WEST SUSSEX COUNTY COUNCIL CONSULTATION

TO:	Arun District Council FAO: Andrew Wood
FROM:	WSCC - Highways Authority
DATE:	23 October 2020
LOCATION:	4 Beachlands Close & land rear of 18 Montpelier Road East Preston BN16 1JZ
SUBJECT:	EP/115/20/PL Side extension, loft conversion & detached garage to existing dwelling & erection of 2 No semi detached houses. This site is in CIL Zone 4 & is CIL Liable as new dwellings.
DATE OF SITE VISIT:	n/a
RECOMMENDATION:	More Information
S106 CONTRIBUTION TOTAL:	n/a

18 BEECHLANDS COURT, EAST PRESTON, BN16 1JZ	
Client	Description
c/o RSP ARCHITECTS LTD	NEW SEMI-DETACHED HOUSE PLANS AND ELEVATIONS

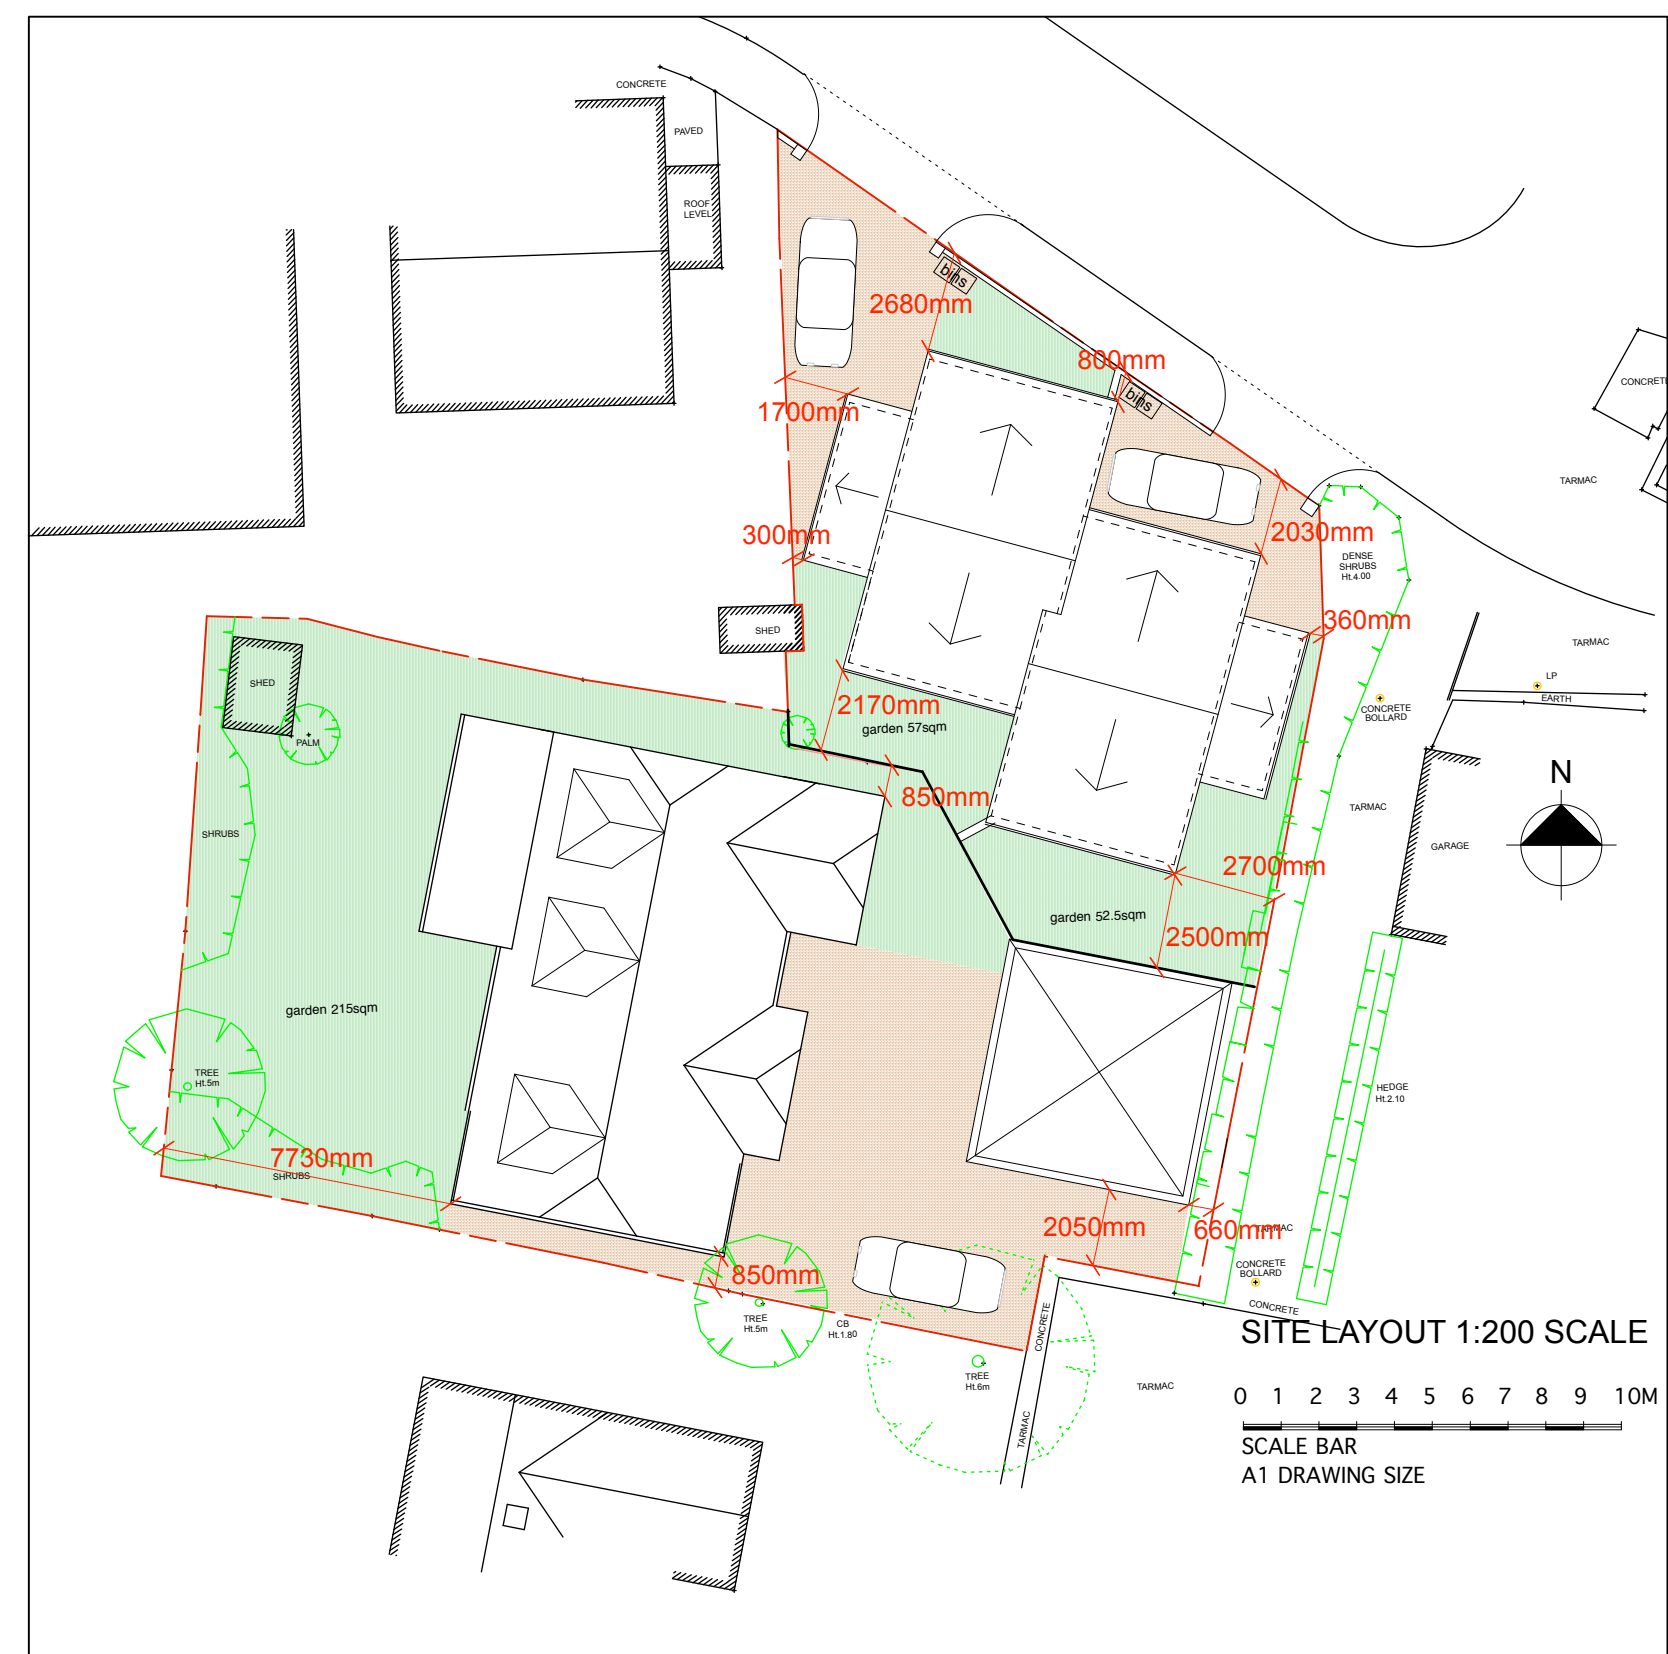
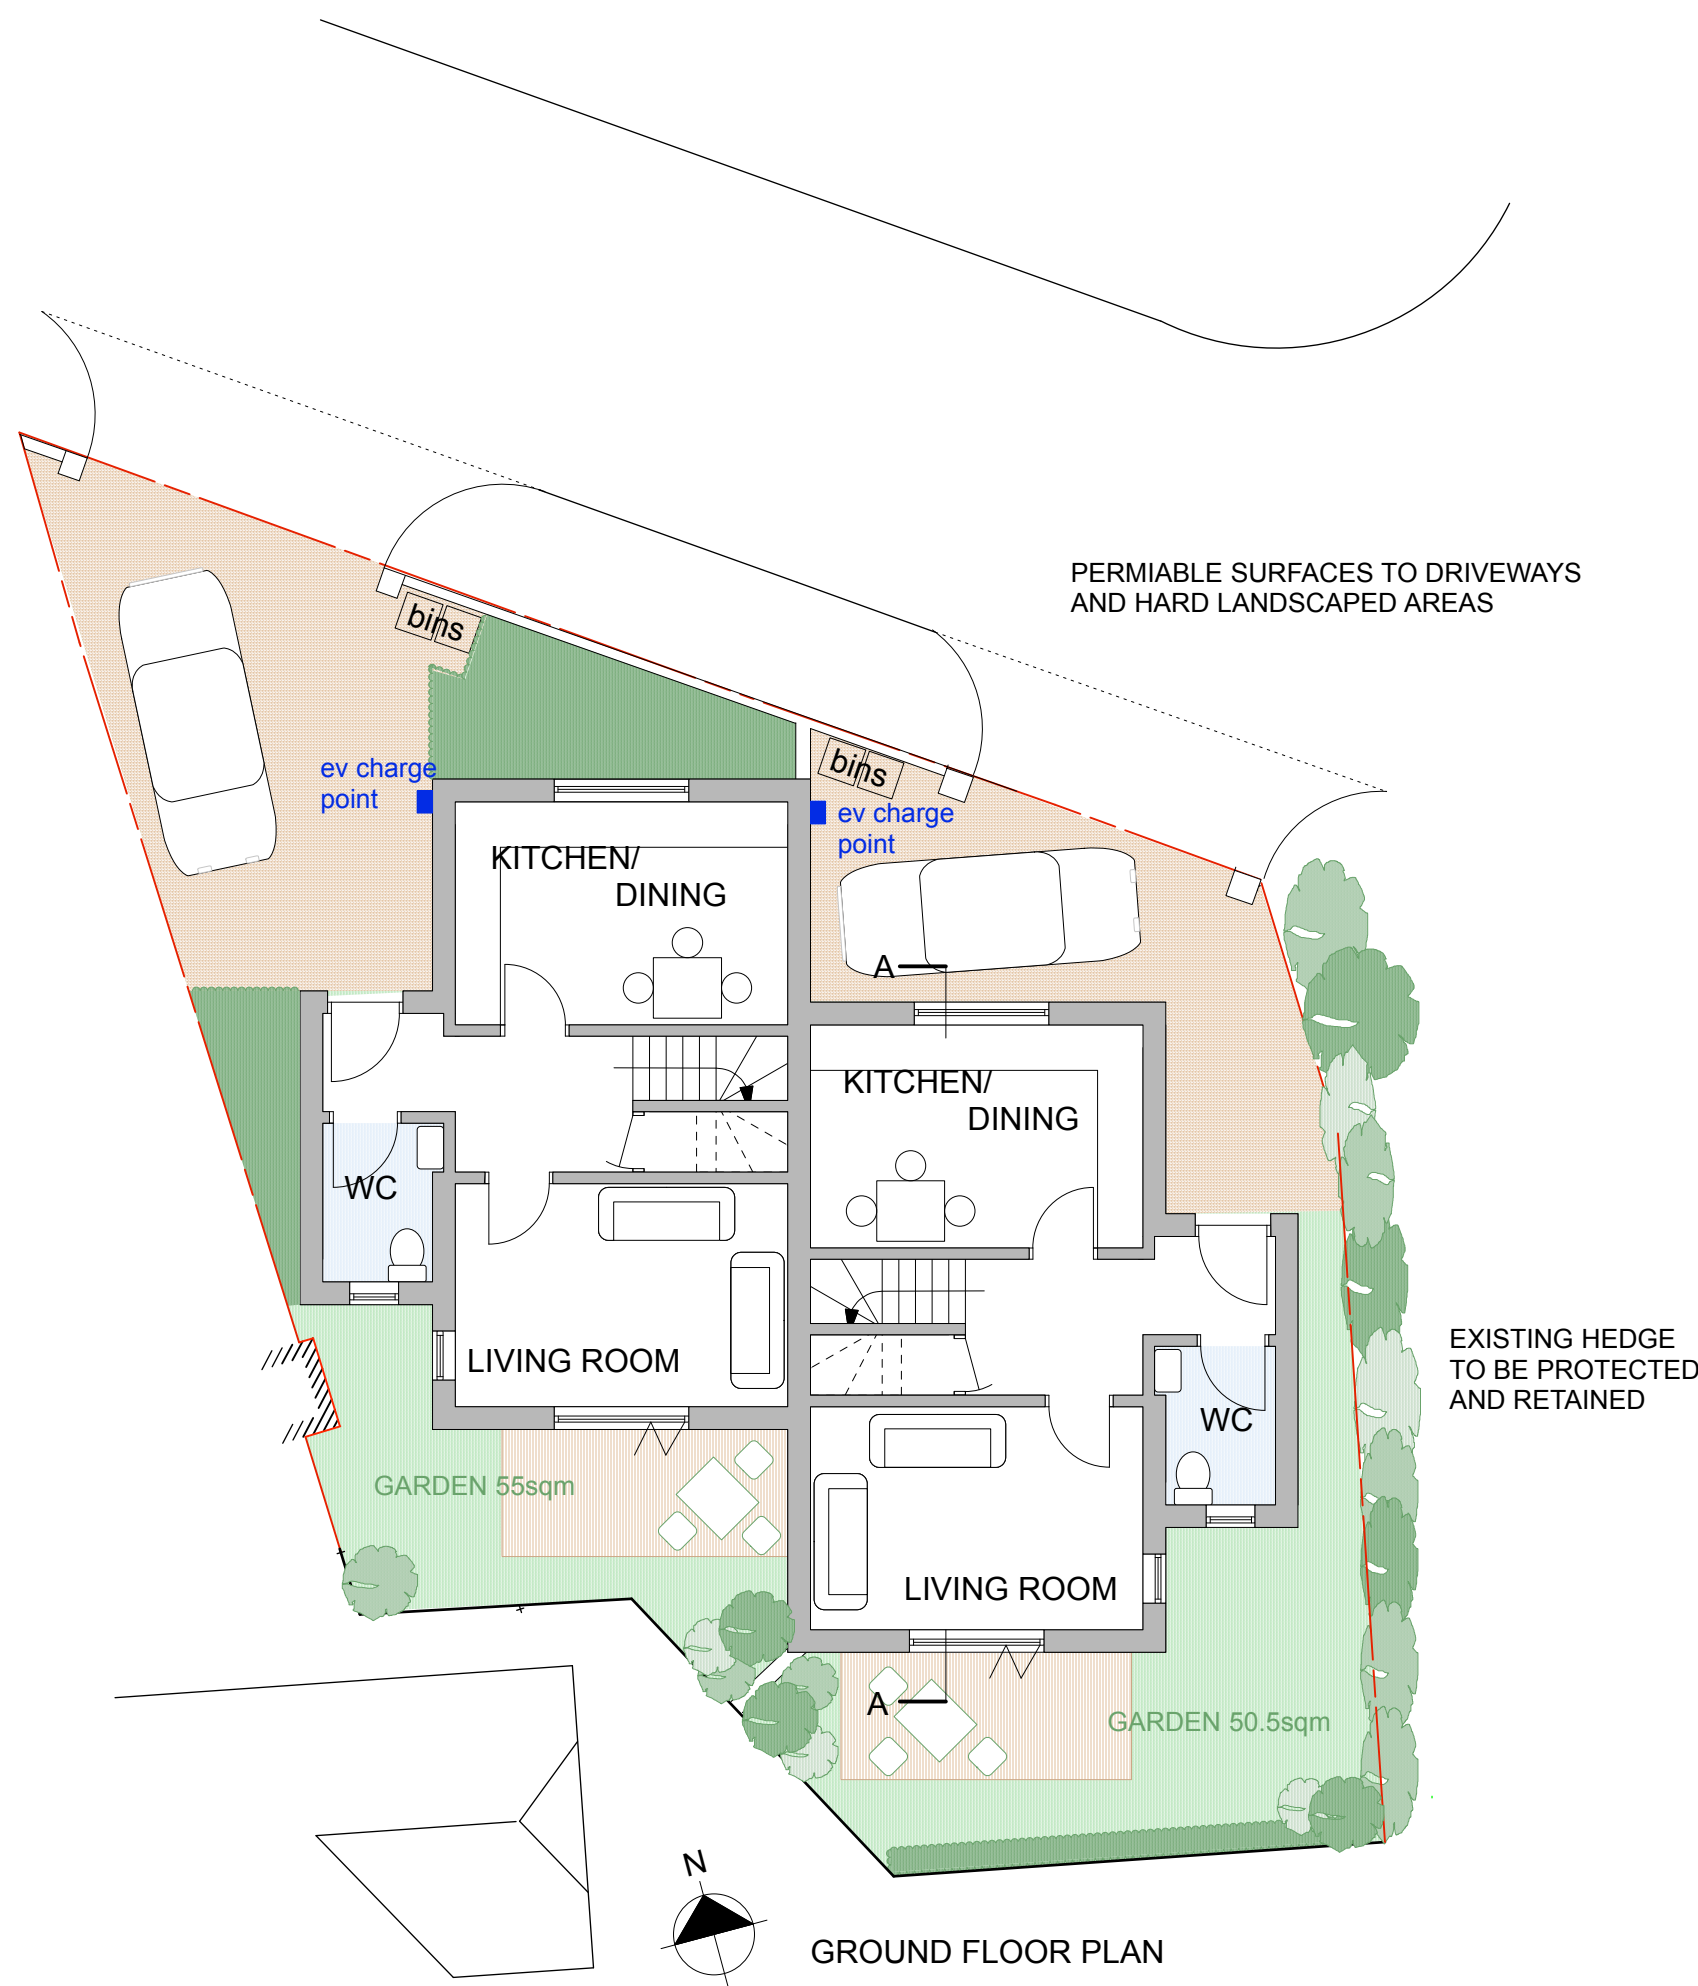
The provided one area that is large enough to accommodate a vehicle. The LHA advises that the applicant amends the proposal to allow for both properties to have at least one parking space each.

The applicant has proposed a NIL cycle parking provision, as per the WSCC Sustainability policy we wish to see cycle storage implemented in the form of lockable covered storage.
